**Notice of Exhibition of application for SCEGGS Darlinghurst Adaptive Re-use of Wilkinson House (SSD-19989744)**

Thank you for your referral dated 7 March 2022 inviting comments from the Heritage Council of NSW on the above State Significant Development (SSD) proposal.

As delegate of the Heritage Council of NSW, I provide the following comments:

DWG TITLE
DEMO NORTH ELEVATION
DWG NO
DA061
REV
A

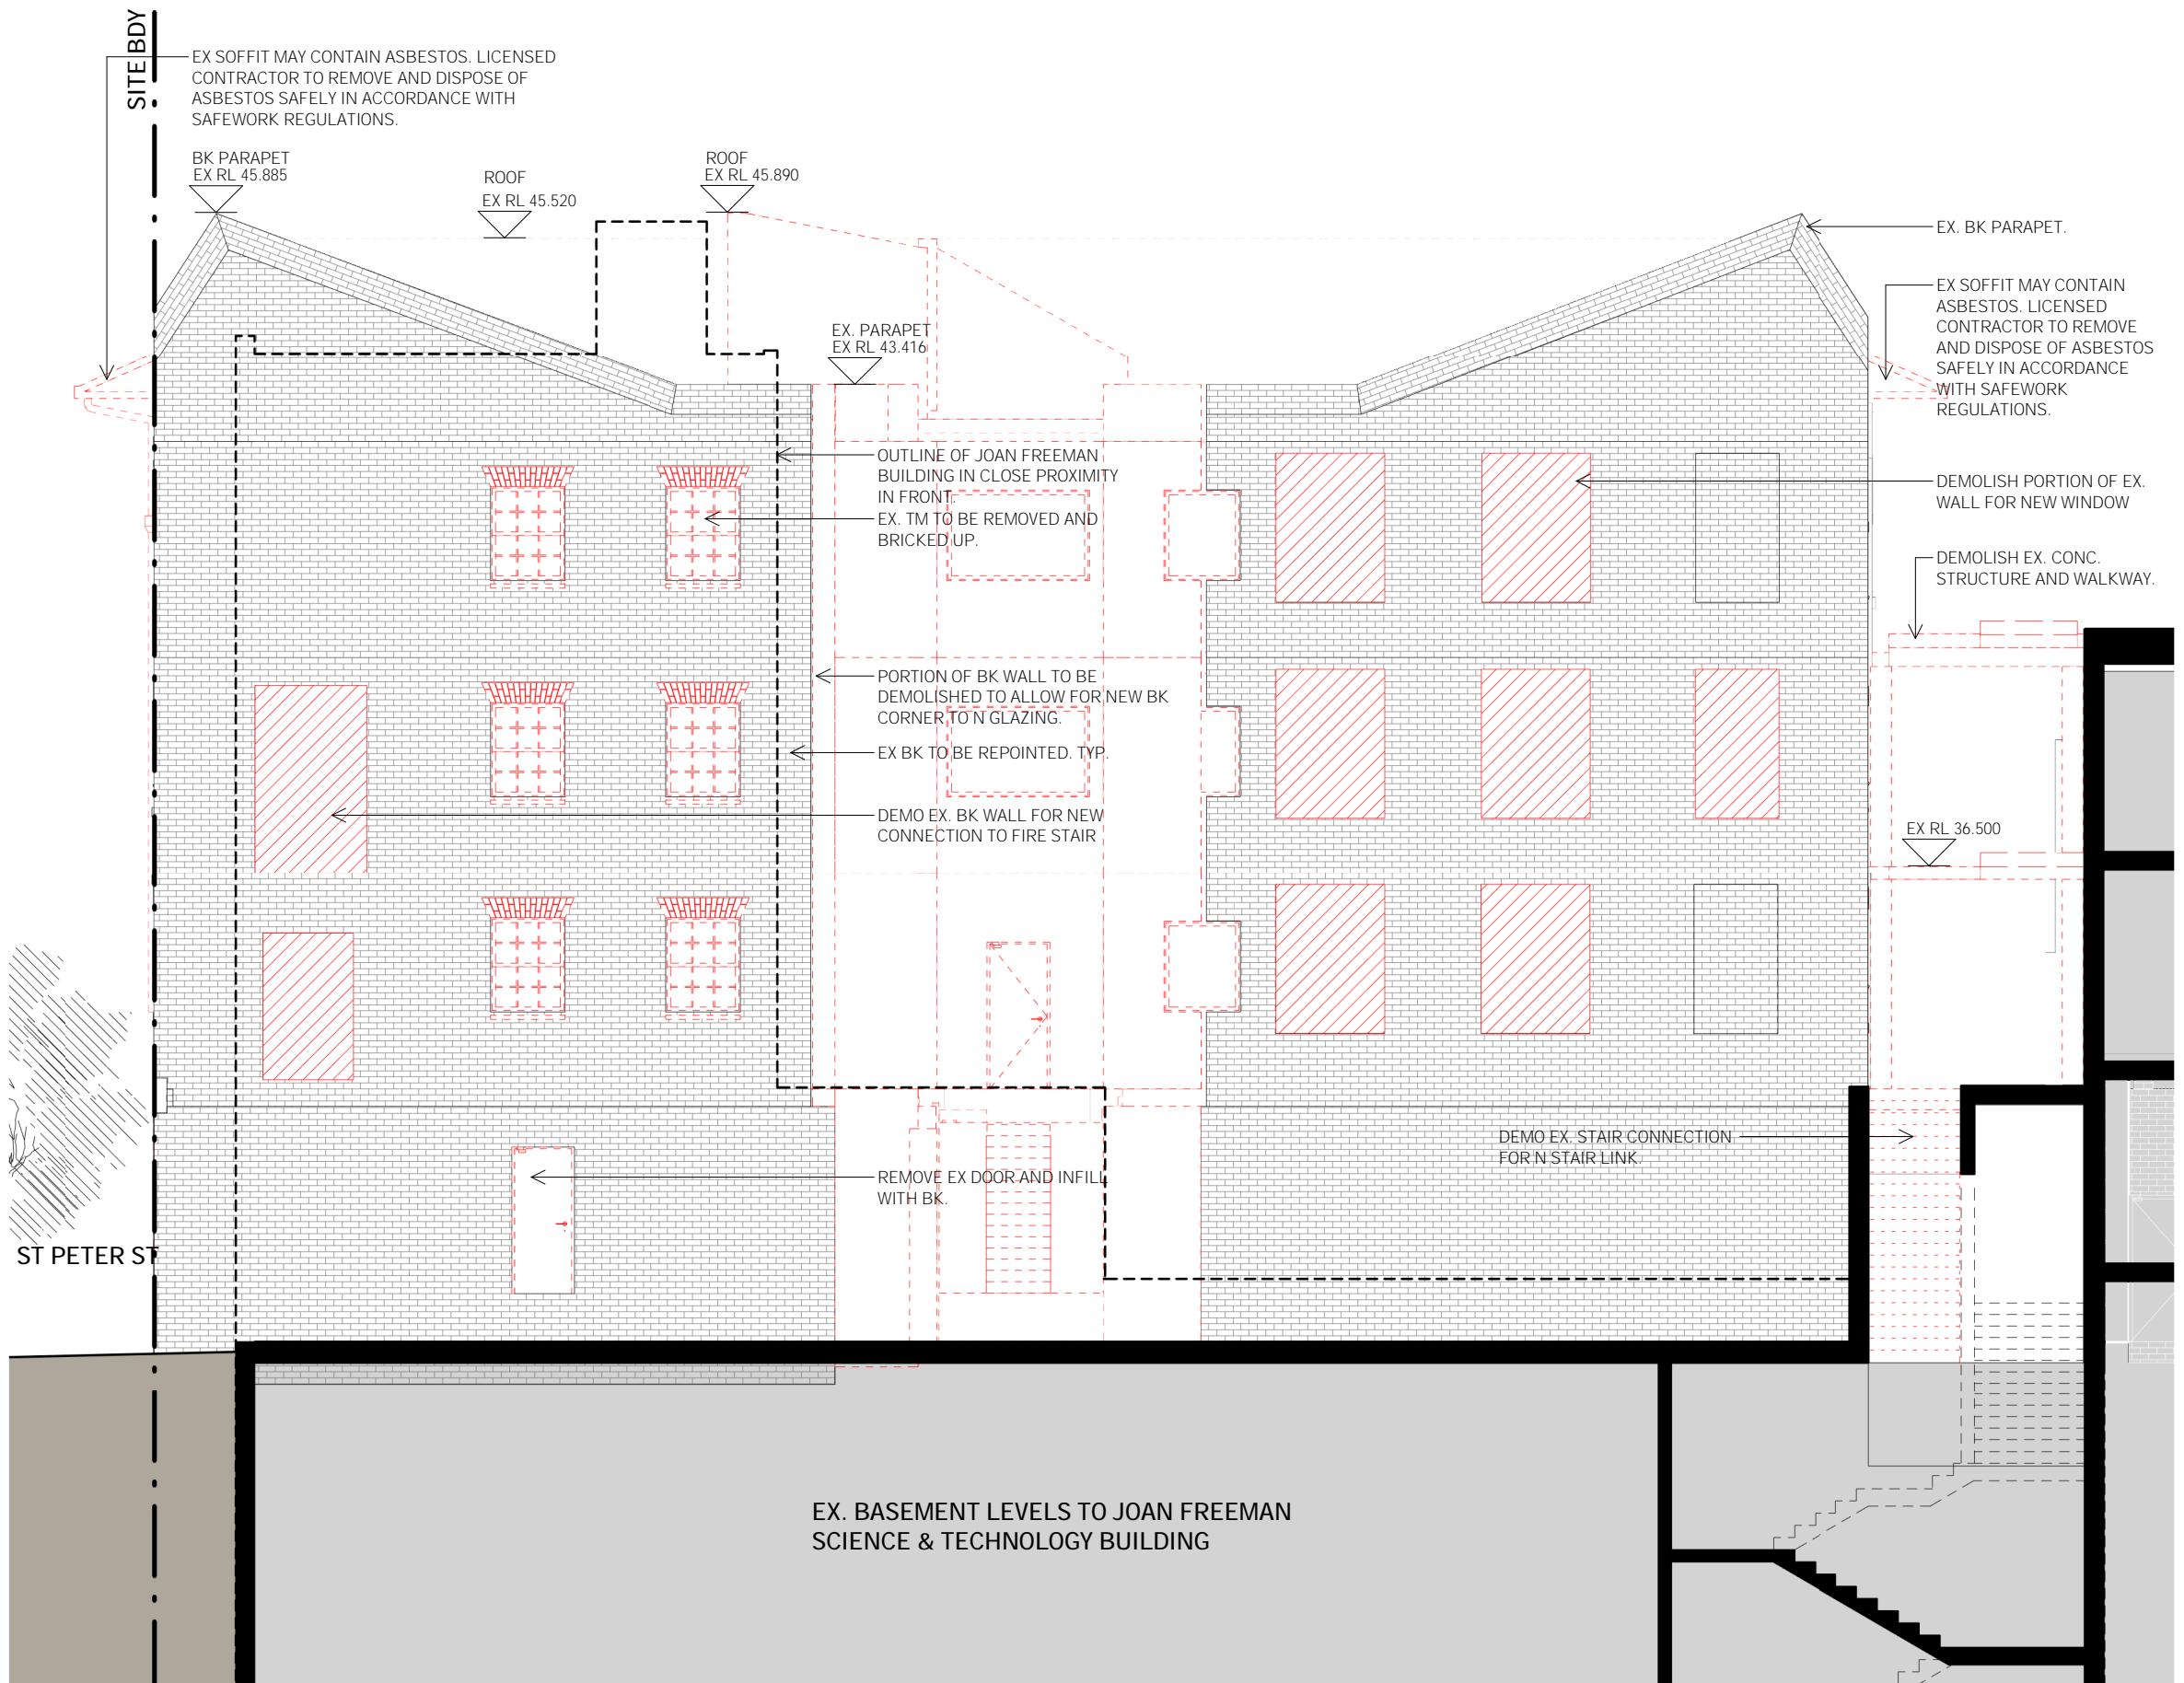
- Restoration of external elevations and removal of intrusive later additions is considered a positive outcome.
- The inclusion of recessed glazing along the balconies would have negligible impact upon the SHR item in the vicinity as the transparent glazing would remain unnoticeable.

DWG TITLE
NORTH ELEVATION
DWG NO REV
DA401 A

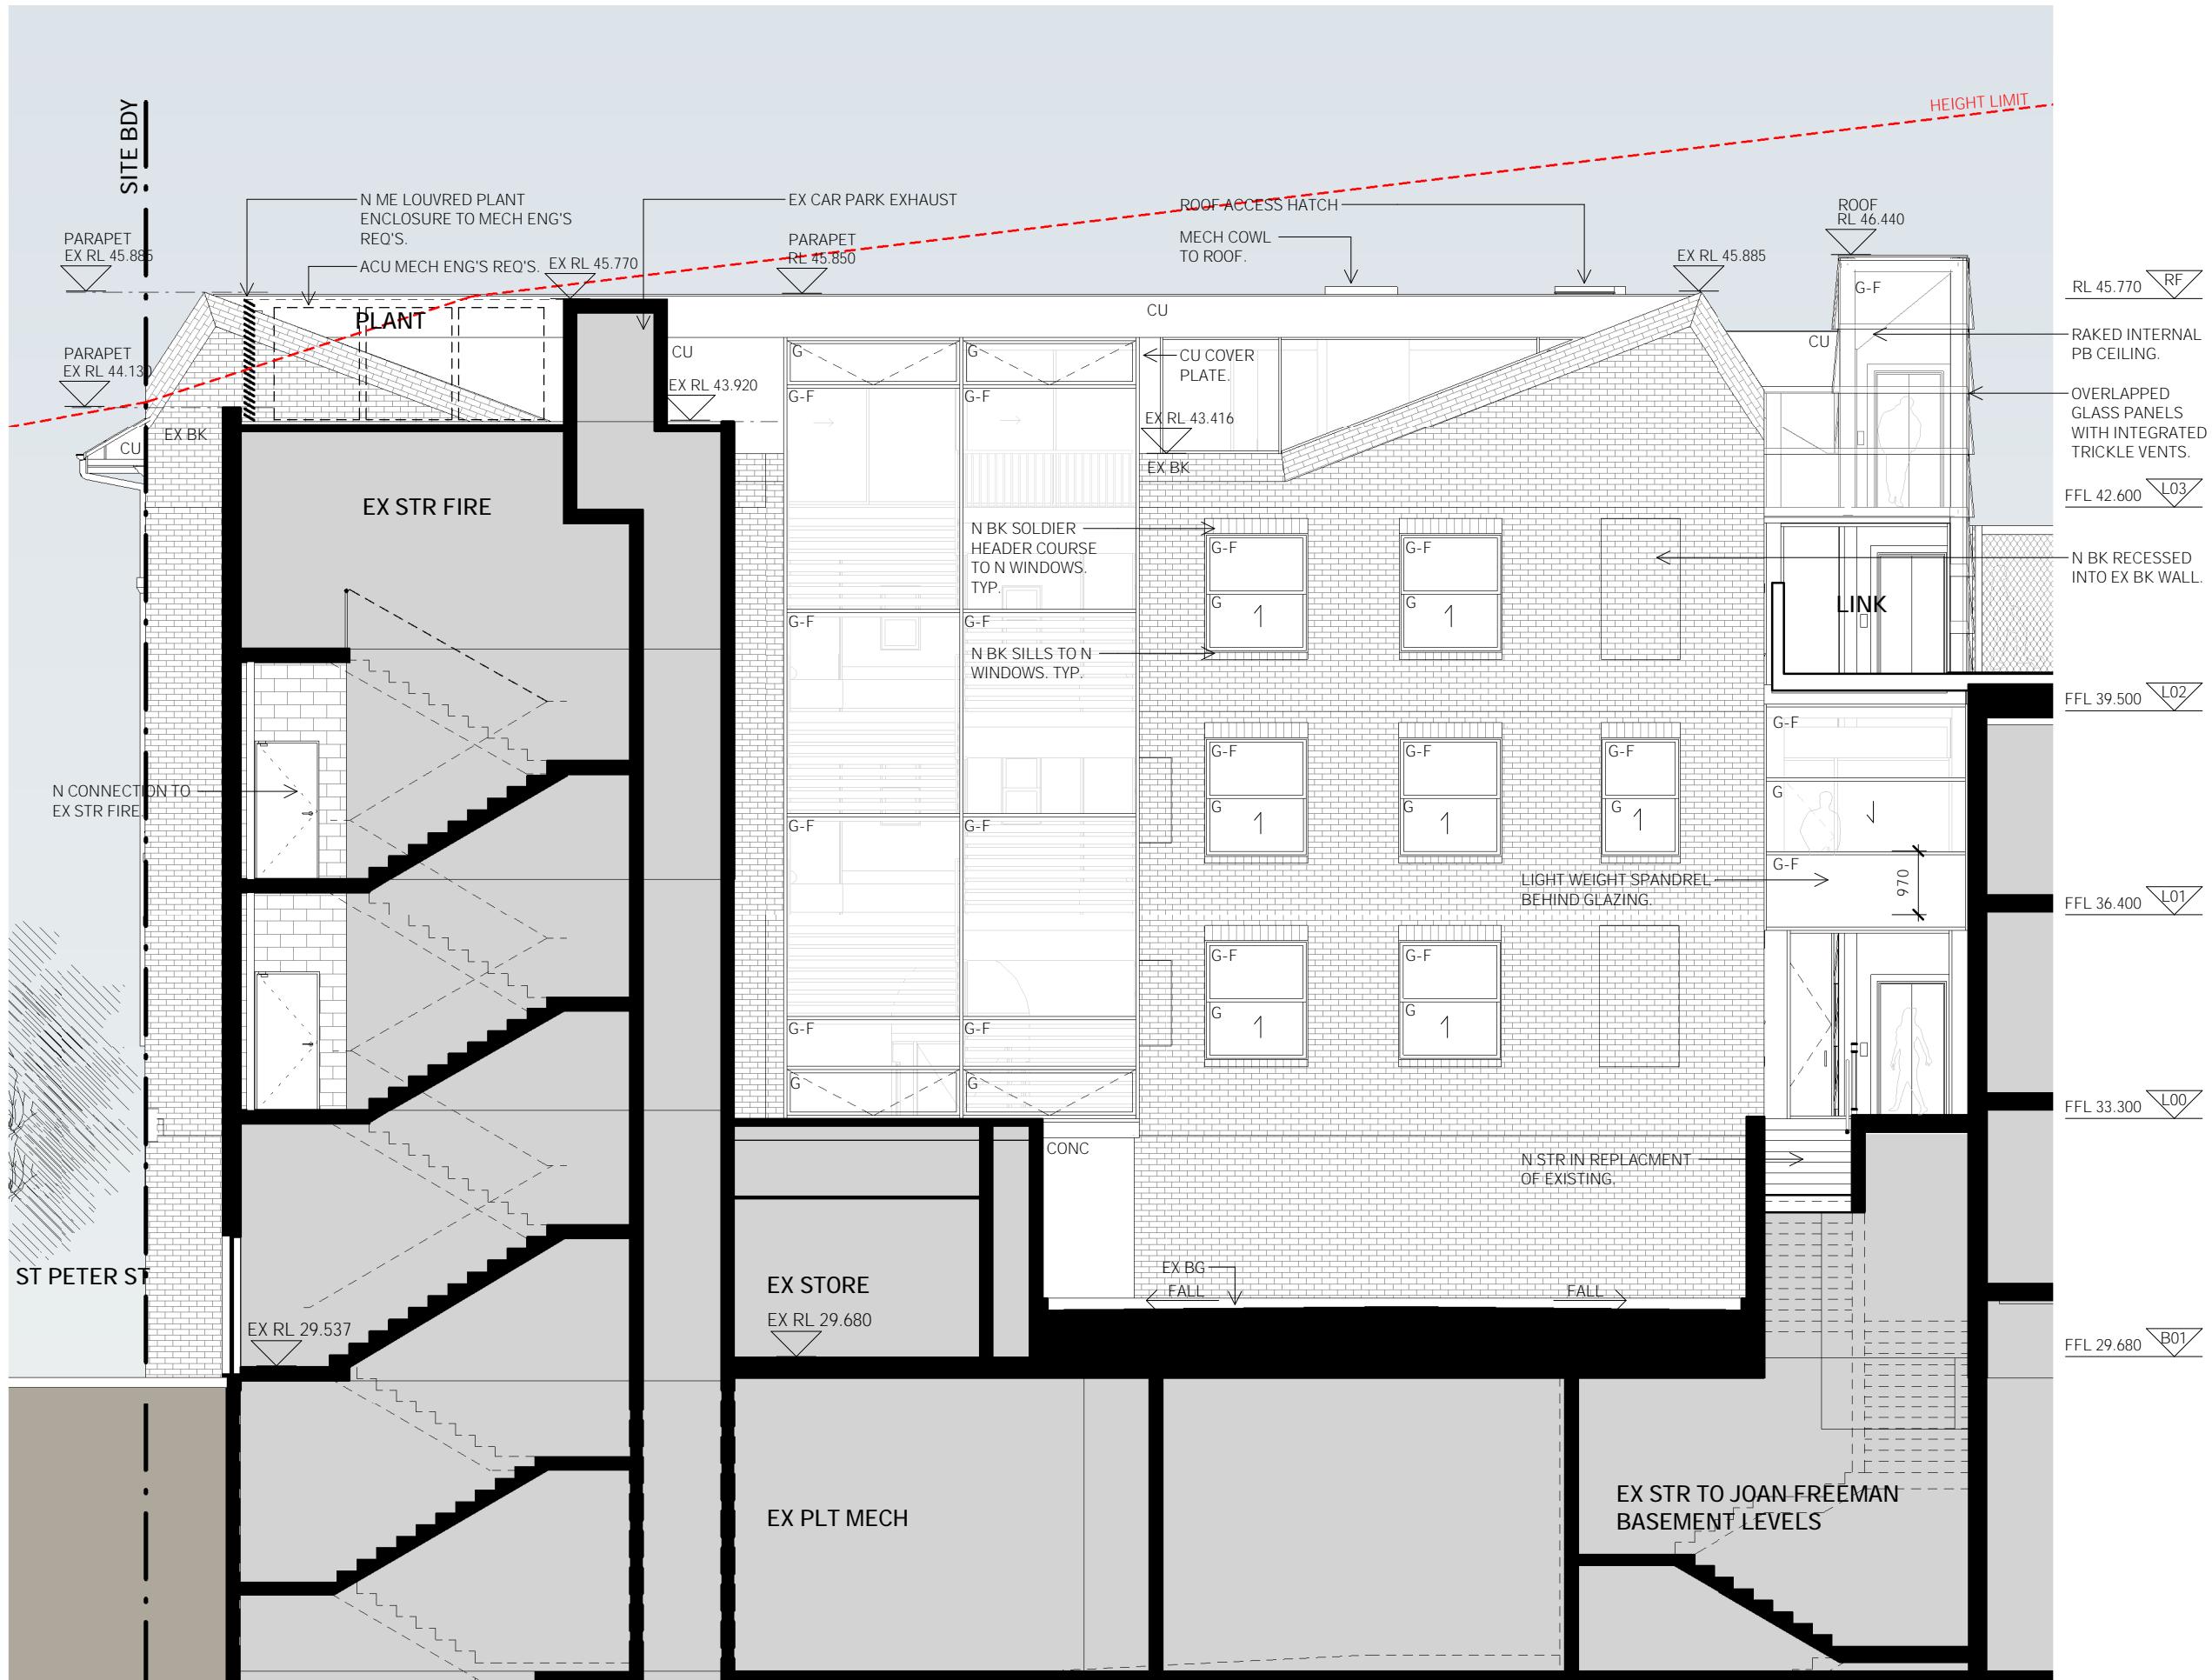
- The proposal confirms that external elevations are being retained with an alteration along the south façade and a change in roof height. These works remain largely invisible from the curtilage of the SHR listed St. Peter's Church and Precinct.
